From: Nia Russell [REDACTED]
Sent: 23 October 2017 11:52
To: Michael Eastham
Cc: Arfon Hughes
Subject: Fwd: Saltbox, Bognor Regis - Heads of Terms

From: karen jenkins [REDACTED]
Subject: RE: Saltbox, Bognor Regis - Heads of Terms
Date: 23 October 2017 at 11:04:11 BST
To: Arfon Hughes [REDACTED]
Cc: Nia Russell [REDACTED] Reg Kirk [REDACTED]

In Nia's absence, there are just two design details that have arisen regarding the Unit 2 Warehouse:

NOTE:
TOPOGRAPHICAL SURVEY, OS DATA, SITE PLAN
OVERLAY SHOWN INDICATIVELY AND SHOULD BE
COMPLETED BY ARCHITECT.

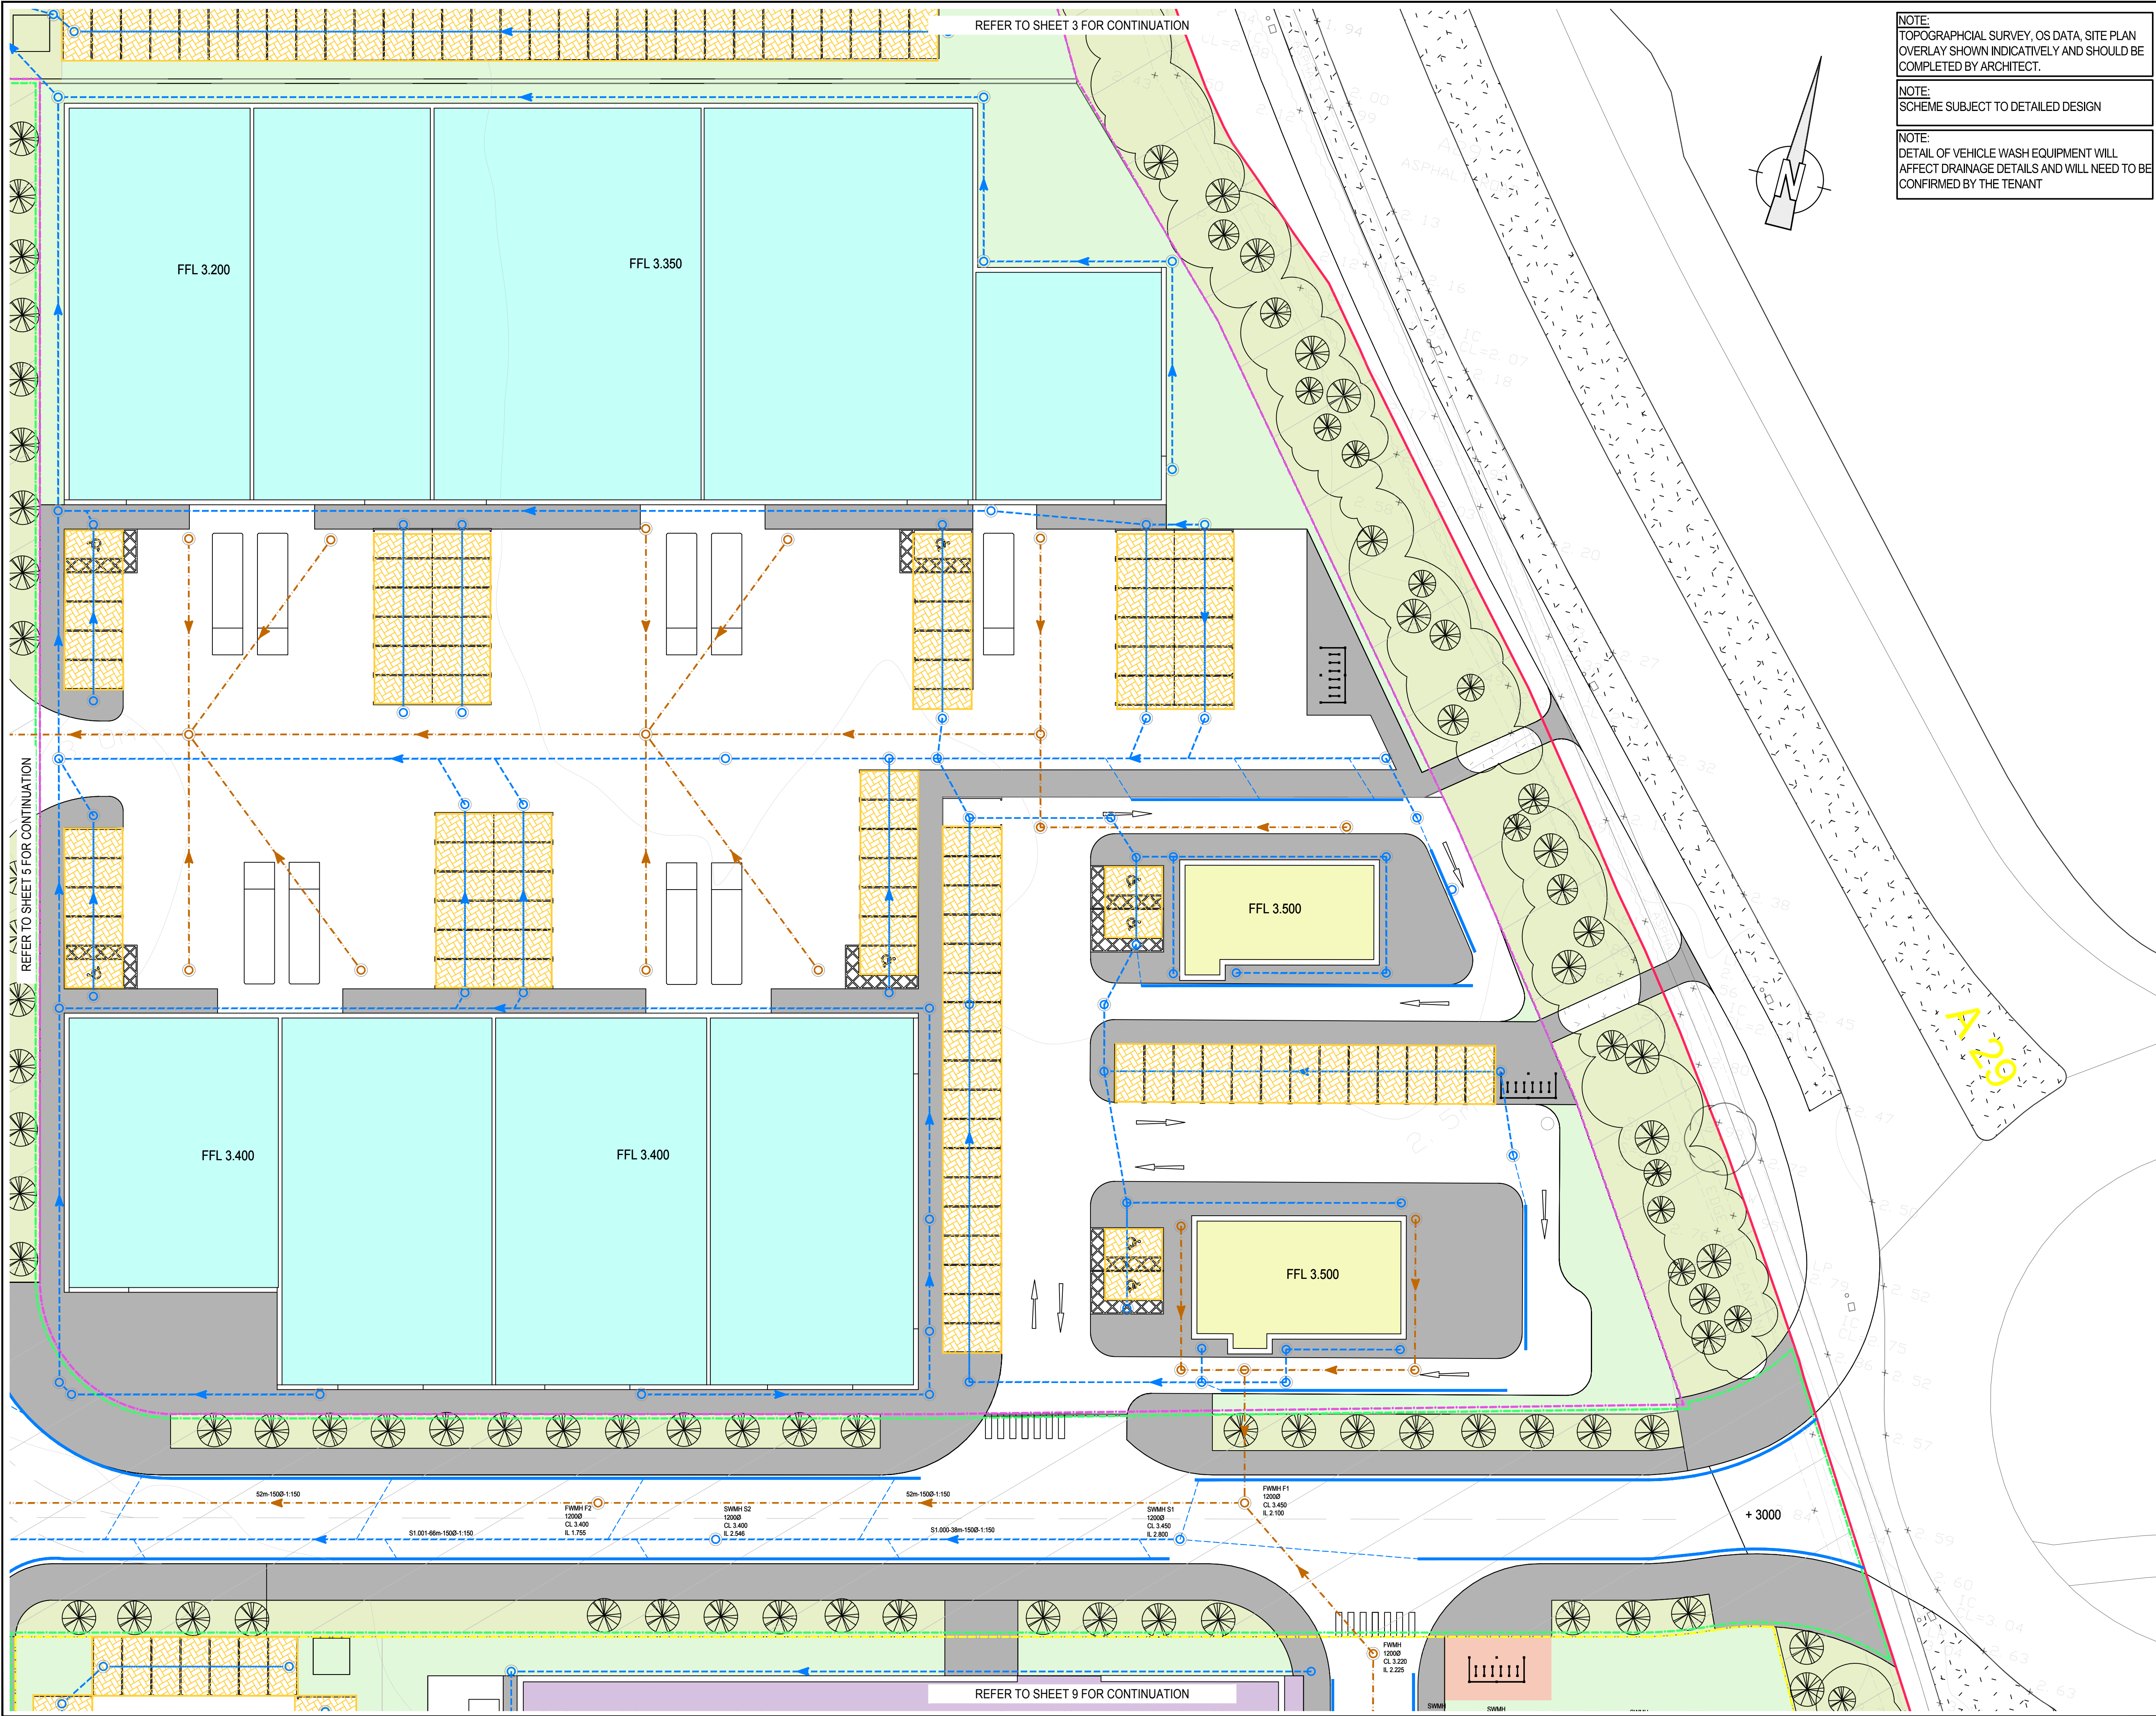
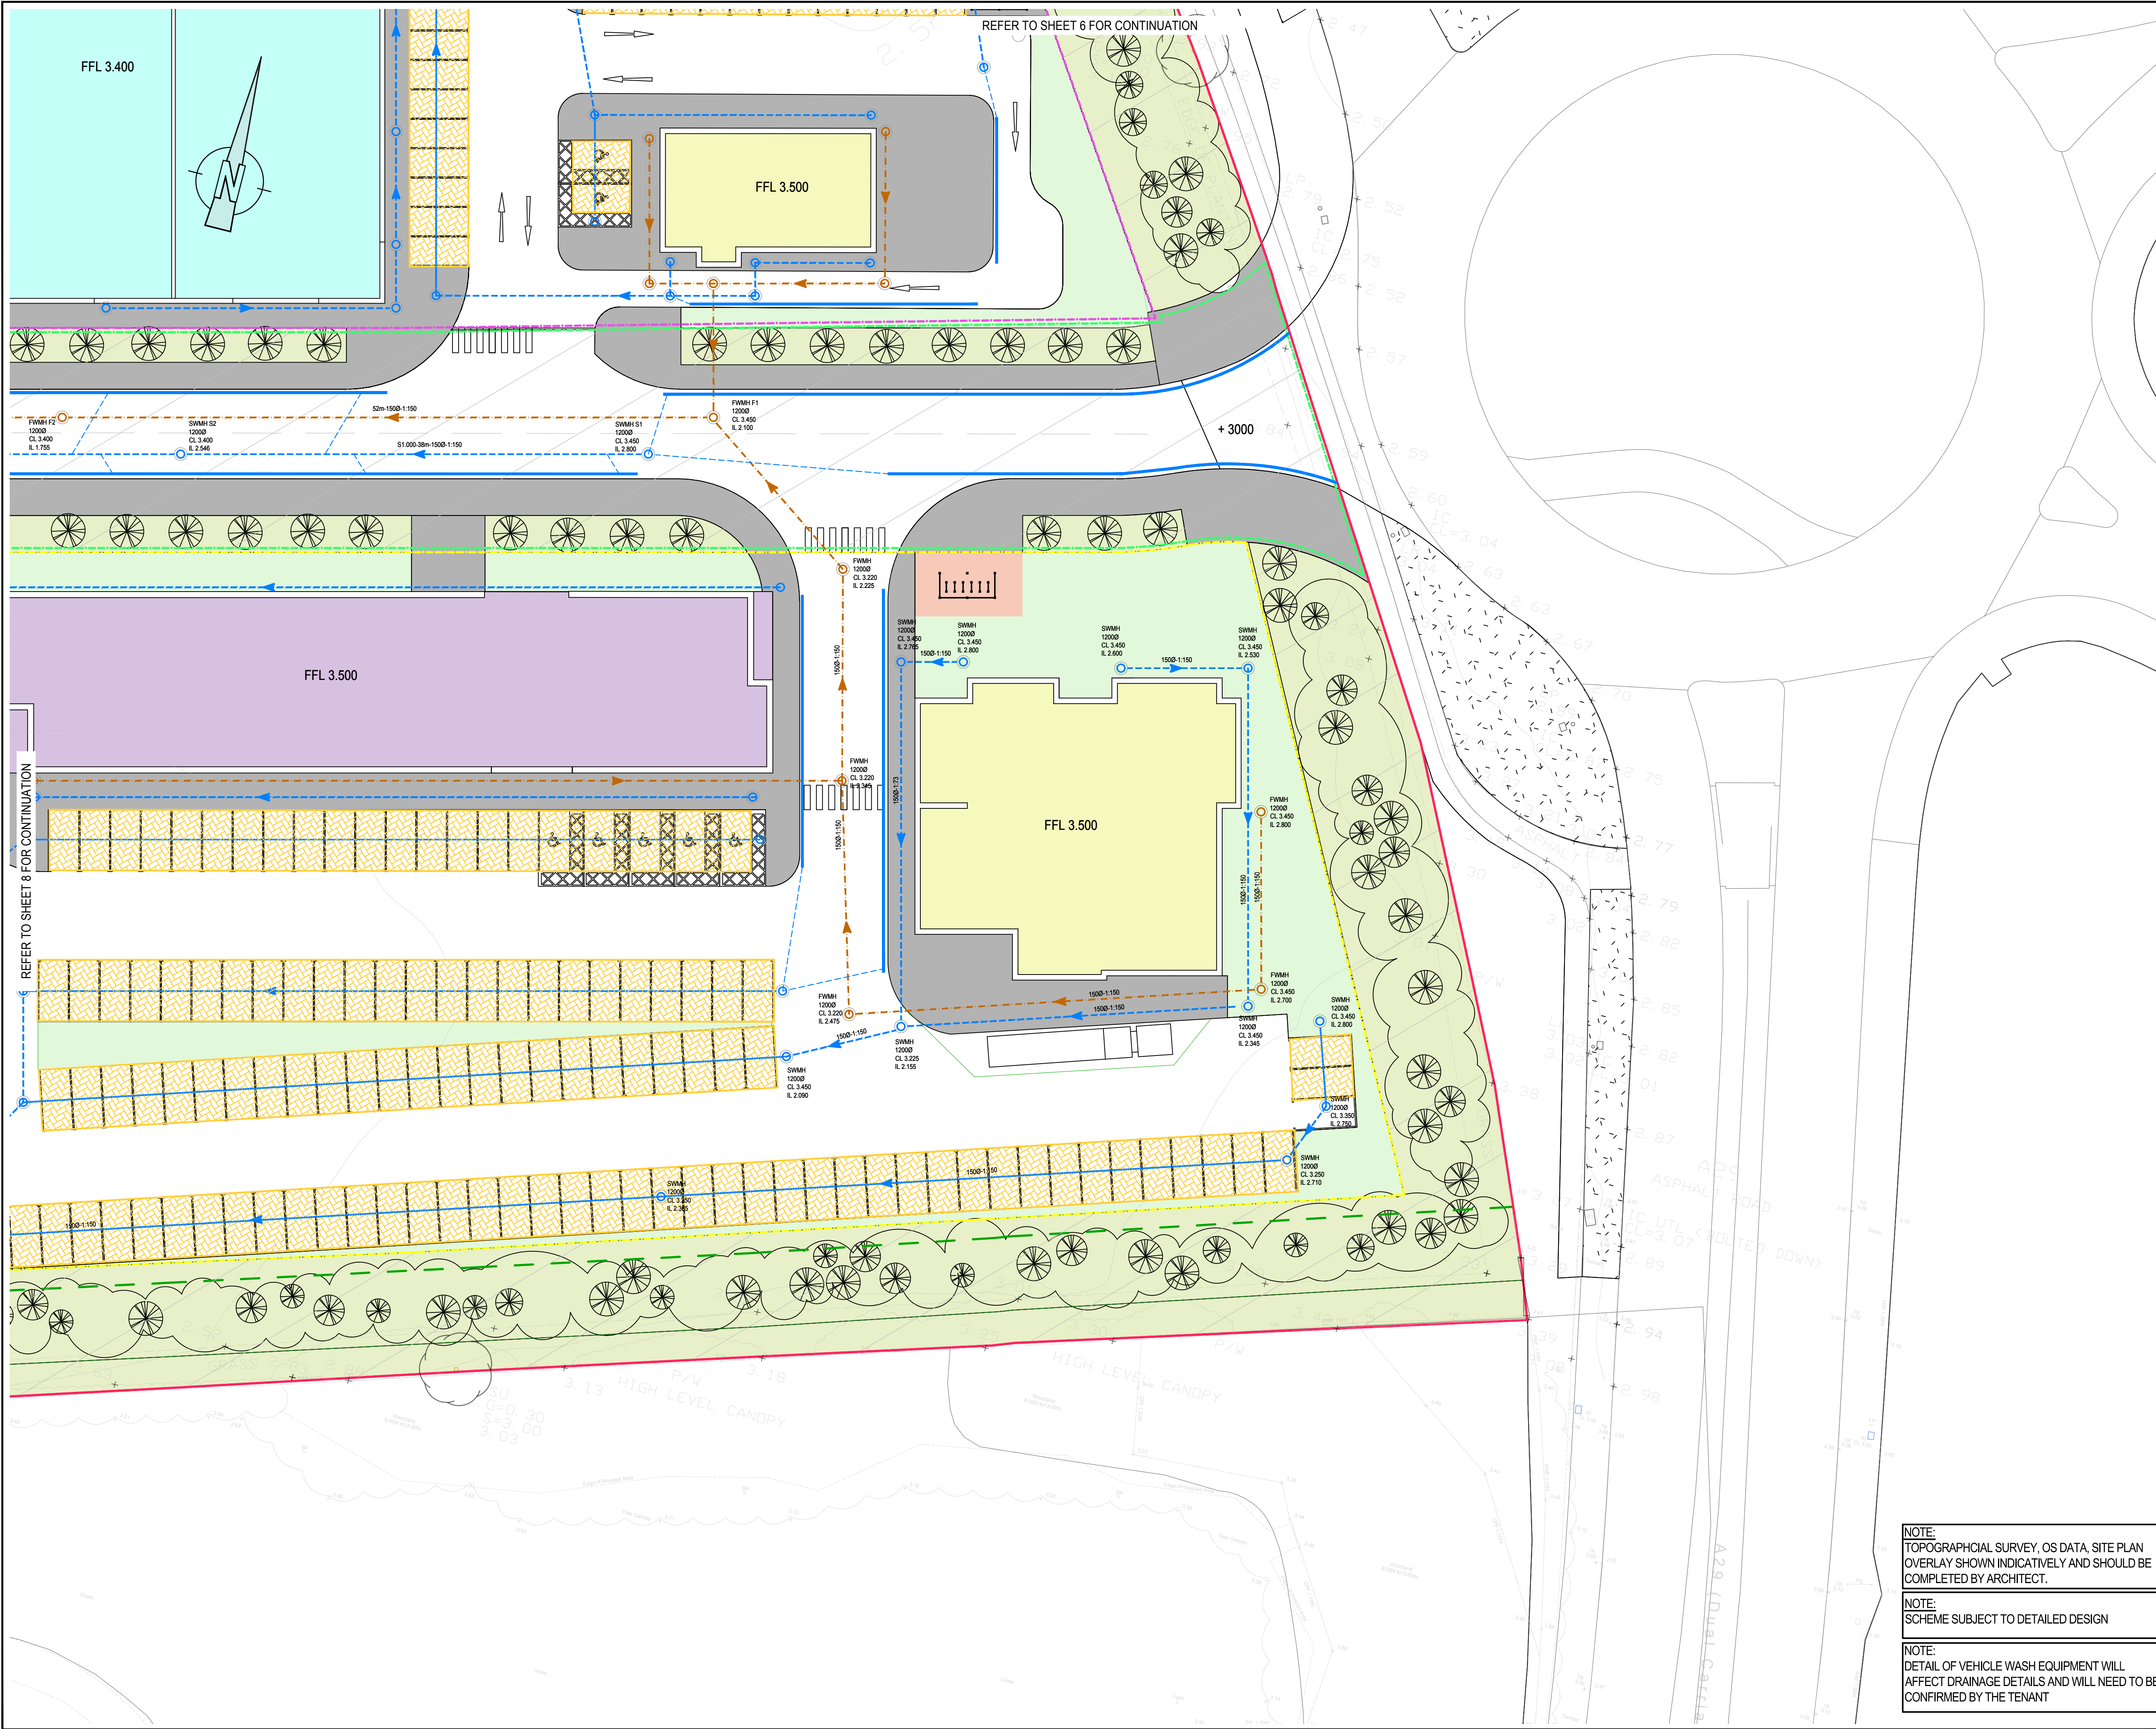
- 3) The Environment Agency normally discourages the use of on-site water treatment plants. Do you need an on-site water treatment plant?

For the Saltbox parcel (which forms part of the Bognor Enterprise Zone), Southern Water, as the local water authority, were contacted and confirmed that there is currently no means of disposal for the foul water at the site, and the local sewerage infrastructure does not have capacity to take the proposed foul water flows from site. If a site has no means of drainage to an existing public sewer due to third party land, the developer can formally request a new public sewer. This means that the water authority can provide a foul water sewer to serve the site.

A S98 solution was been prepared by Southern Water in May 2015 for the site, that indicates costs associated with a pumped system. Based on the information within the report, 674m of a 2m deep rising main and assuming £1000/m construction cost. The works are therefore valued at CRICA £700,000 which is to be paid by the developer. Based on this value, it is not financially viable for the development to progress with the Section 98 Application. In addition, based on other similar schemes, it is estimated that the S98 design process will take between 52-78 weeks before works can start on site.

Initially, a 3 stage wastewater system is proposed for the Saltbox site to deal with the foul water flows. The sewage is first settled to remove the solids and then biologically treated in an aerated biozone, consisting of rotating discs, or air injection, with a final settlement stage to remove the fine solids. The effluent is discharged, on average, 95% clean, to a land drainage system, then finally the watercourse, (subject to Local Authority and Environment Agency Consents).

The treatment system must meet the relevant British Standard at the time of installation. The standards currently in force for new systems are BS EN 12566. The clean treated discharge is subject to Environment Agency 'Consent to Discharge', prior to any flows being discharged directly the watercourse.

It is anticipated that the foul water treatment plant will be overall more financially viable for the scheme, although the final costs are still TBC. In relation to the programme, it is expected will take less time to implement. Hence, is the preferred option for the disposal of foul water sewerage from the proposed Saltbox site.
